KITTITAS COUNTY FIRE MARSHAL'S OFFICE

February 7, 2025

Fire Marshal comments
Parke Creek Landing
PD-24-00001

SITE DEVELOPMENT PLAN - PARKE CREEK LANDING  
A PORTION OF THE NW 1/4 & A PORTION OF THE SW 1/4 OF SECTION 34, T. 18 N., R. 20 E., W.M.  
KITITAS COUNTY, STATE OF WASHINGTON

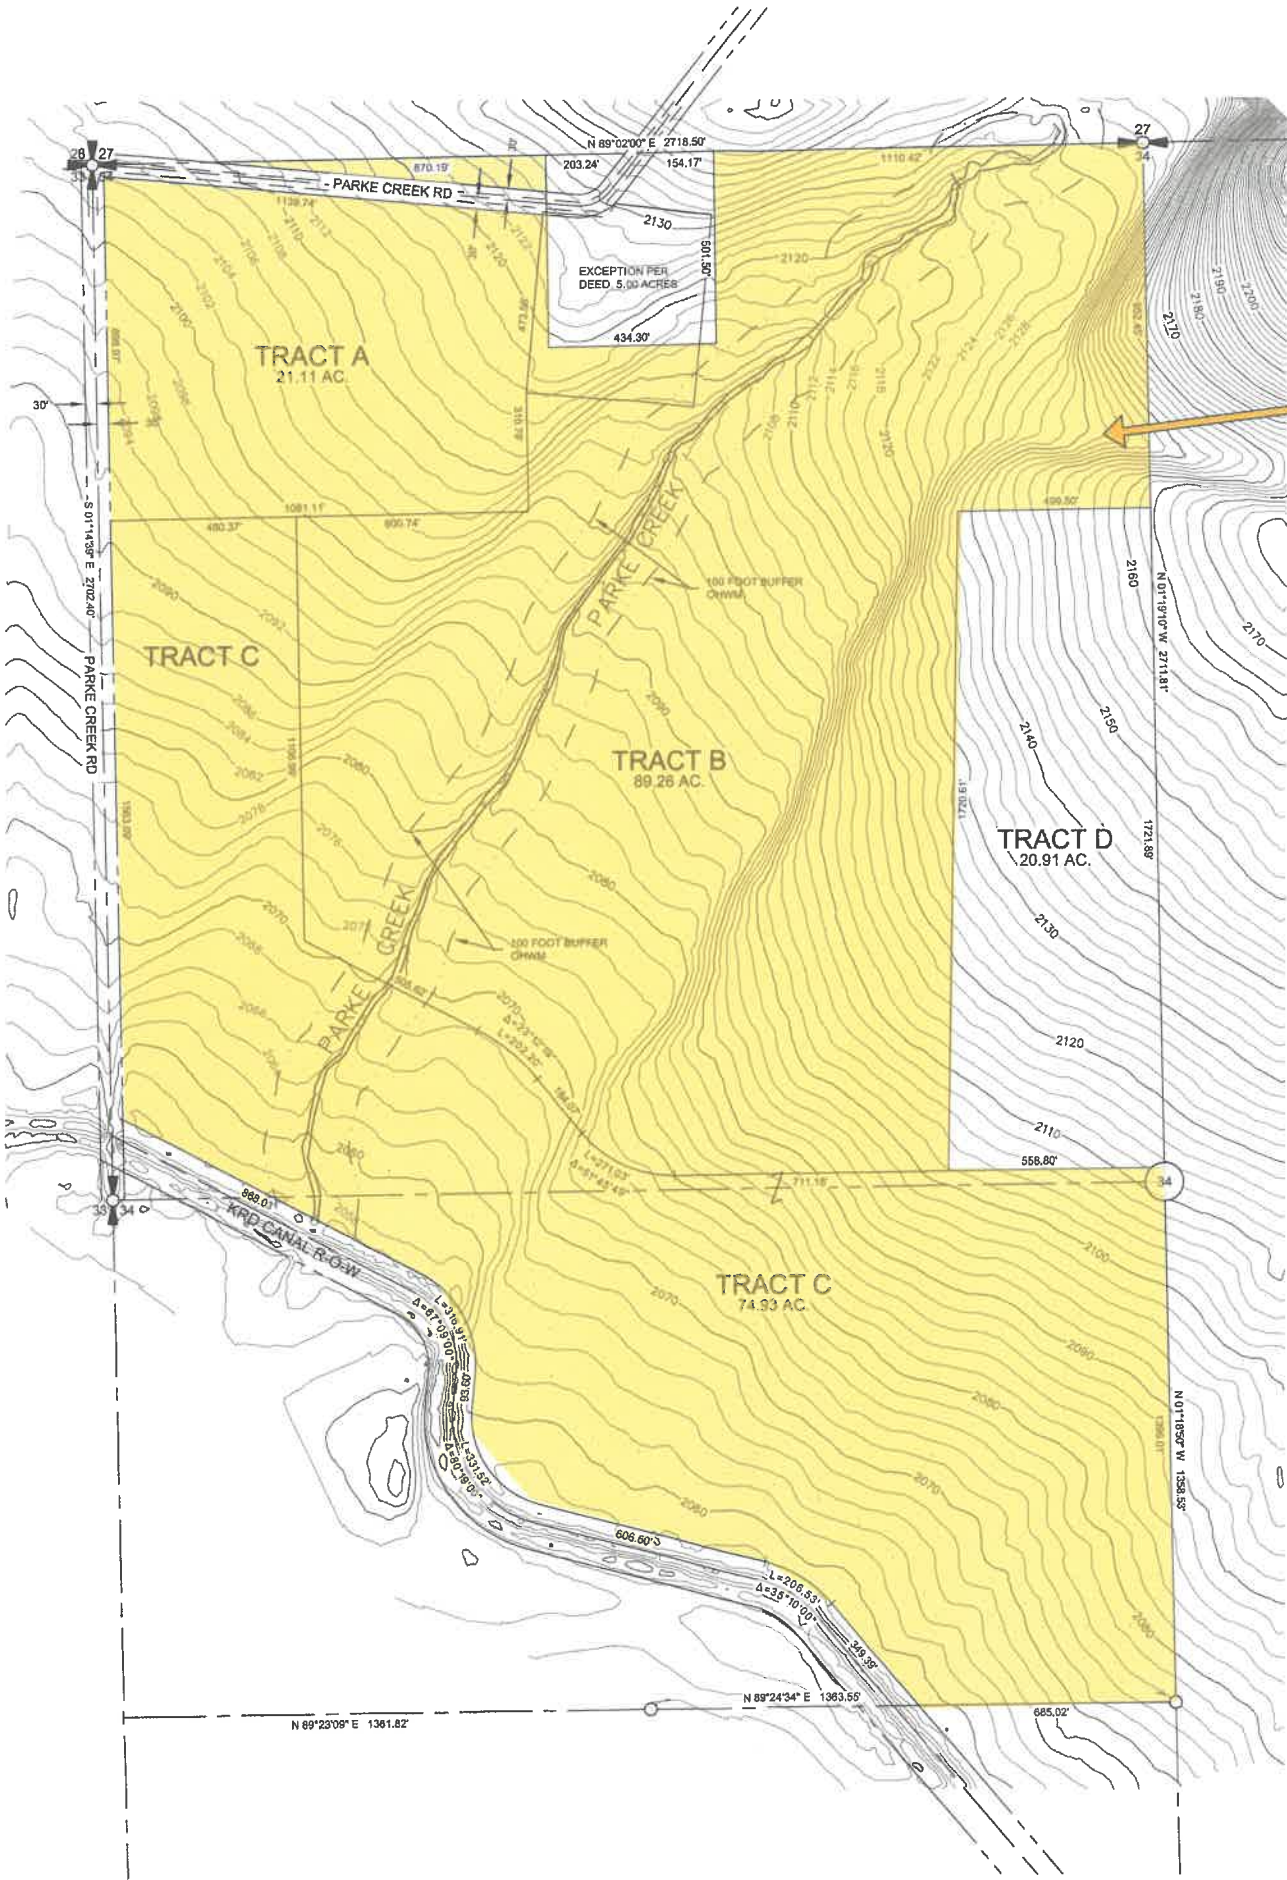
Fire apparatus access is required for this application. The roadways and maneuvering areas as indicated in the application do not adequately provide required fire apparatus access. Provide fire apparatus access roads with an unobstructed width of not less than 20 feet, an unobstructed vertical clearance of not less than 13.5 feet, with an all-weather driving surface and capable of supporting the imposed loads of fire apparatus. Access roads shall extend to within 150 feet of all portions of the facility and all portions of the exterior walls of the first story of the building.

Approved fire apparatus turnarounds are required for this project. The indicated provisions for turning around fire apparatus are not adequate. Provide a turnaround meeting the requirements of the International Fire Code Appendix D.

This application is sited in the designated high fire hazard Wildland - Urban Interface zone. Additional setback, building construction, access, fire flow and addressing requirements will be applied at the time of building permit application. All structures are required to be at least 30 feet from all property lines.
